From: Jeremy Benn [jeremy@joeflynnrealestate.com]
Sent: Monday, September 30, 2013 11:12 AM
To: Rita Sawyer
Subject: RE:
Attachments: DOC093013.pdf

Subject **Re: 133 York Street/Harborview Flats**
From Susan Kaplan <birmanmom@gmail.com>
To Jeremy Benn <jeremy@joeflynnrealestate.com>
Seth Page <sxp@earthlink.net>, Elliot Vrana <elliot.vrana@gmail.com>, Erin Foley <efoley19@aol.com>, Bruce Baker <brucewbaker.me@gmail.com>, Catherine Morrison <cmorrison@createagreement.com>, David Marsden <davidm@homesinmaine.com>, Jean Fraser <JF@portlandmaine.gov>, Erika Johnson <ejjohnson83@gmail.com>, Bill Mitchell <Bill@ghmagency.com>
Cc
Date 2013-09-24 18:00

SITE PLAN MAP 44/BLOCK A/LOTS 29 & 31

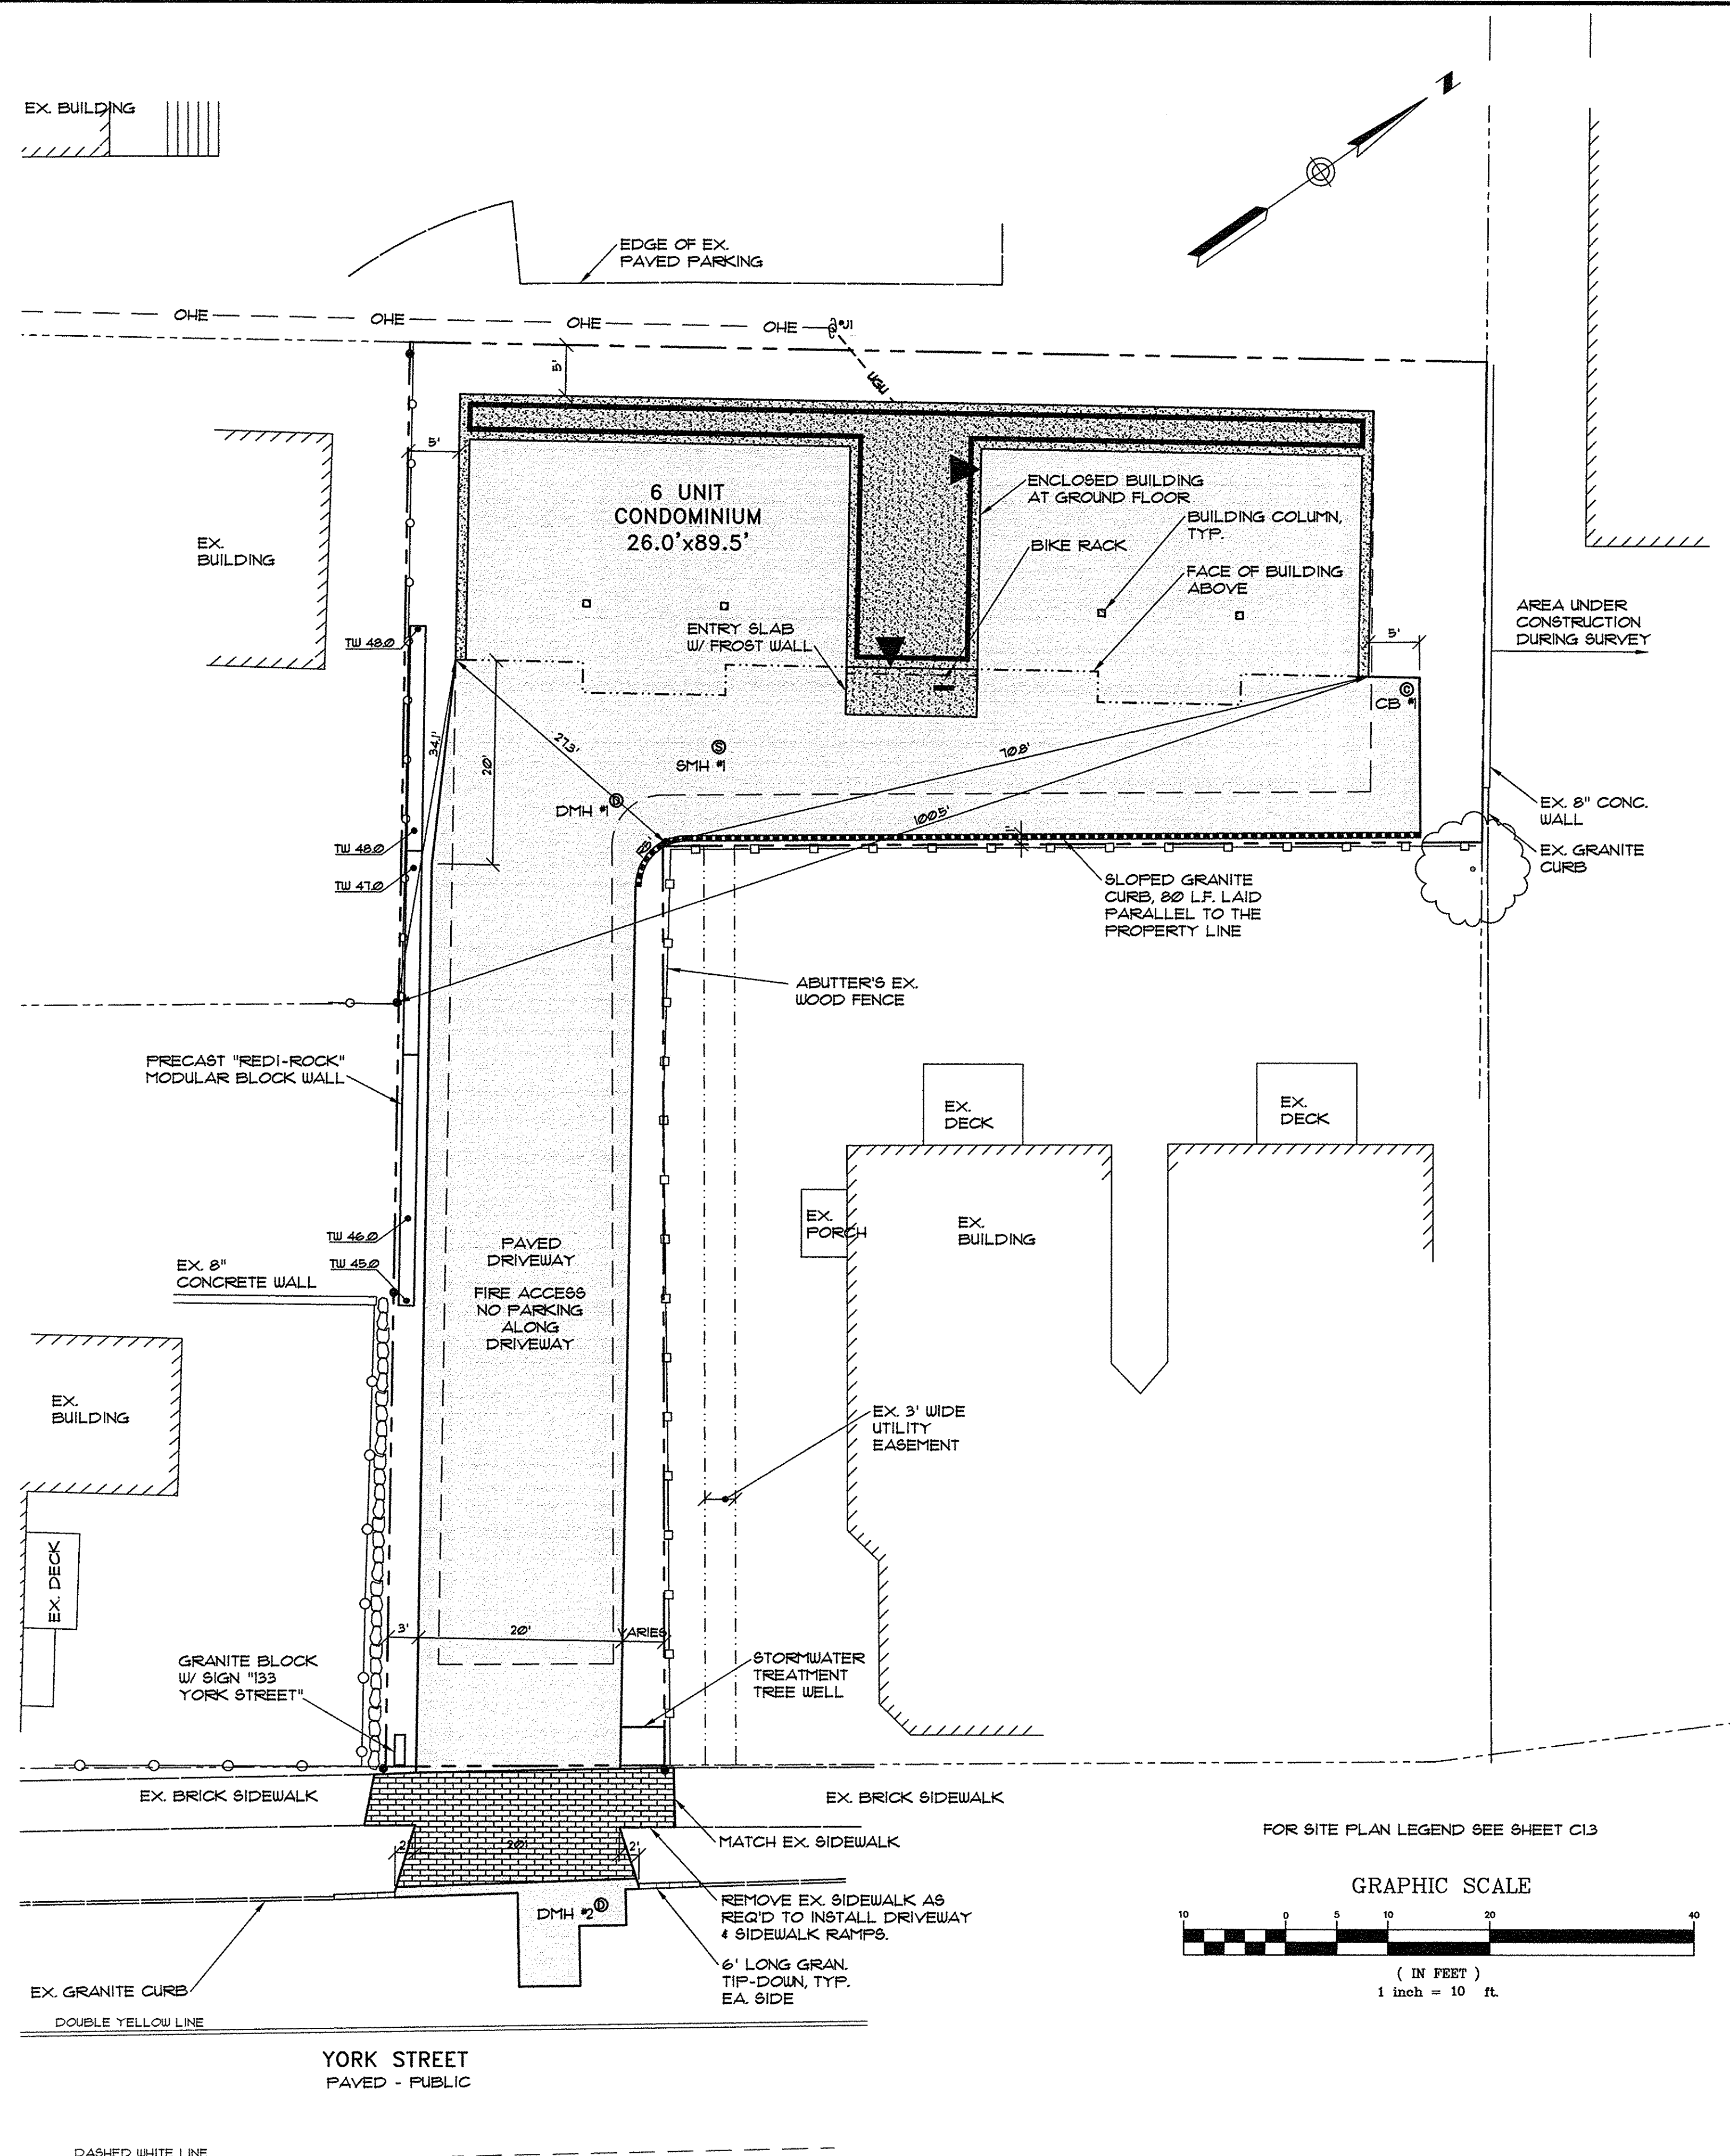
As the plan sits, the headlights from cars that are backed into your parking area will shine directly into the first floor condos (in blue) at the Flats. This unscreened area is noted with the red arrows above. The green wall and trees (as they are currently proposed) will not adequately address our concerns.

- 1) In your present design, is the green wall only planned for the section that is highlighted in yellow in the image below (the corner area)?
- 2) If YES, what provisions (beyond the trees you cited) have you made for affording the Flats screening and privacy from the parking area?

- 3) And finally, do you have any plans for providing privacy or screening to the adjacent Townhomes building?

The suggestions in your email sound like you are moving in the right direction. When you say, "the corner of the fence in your backyard", can you give me a better sense of what area would / would not be screened by the green wall? As the plan sits, the headlights from cars that are backed into your parking area will shine directly into the first floor condos at the Flats. I would be very interested in additional details as to the placement and length of the green wall.

I see your concerns about the headlights as illustrated by the red arrows. I have asked the engineer to update the site plan to show a "green wall" to continue all the way across the fence. I will keep you updated on the façade.

- 1) The green wall goes beyond what you have highlighted, it is represented by the dashed line. It goes to about where the front door is located and further down the driveway.
- 2) The additional provision is in fact the two trees on the plan – this was suggested by the city arborist. We have added the trees and green wall to help with the privacy concerns.
- 3) The extra privacy for the town homes is provided with the additional 12 trees and shrubs as detailed on the plan.
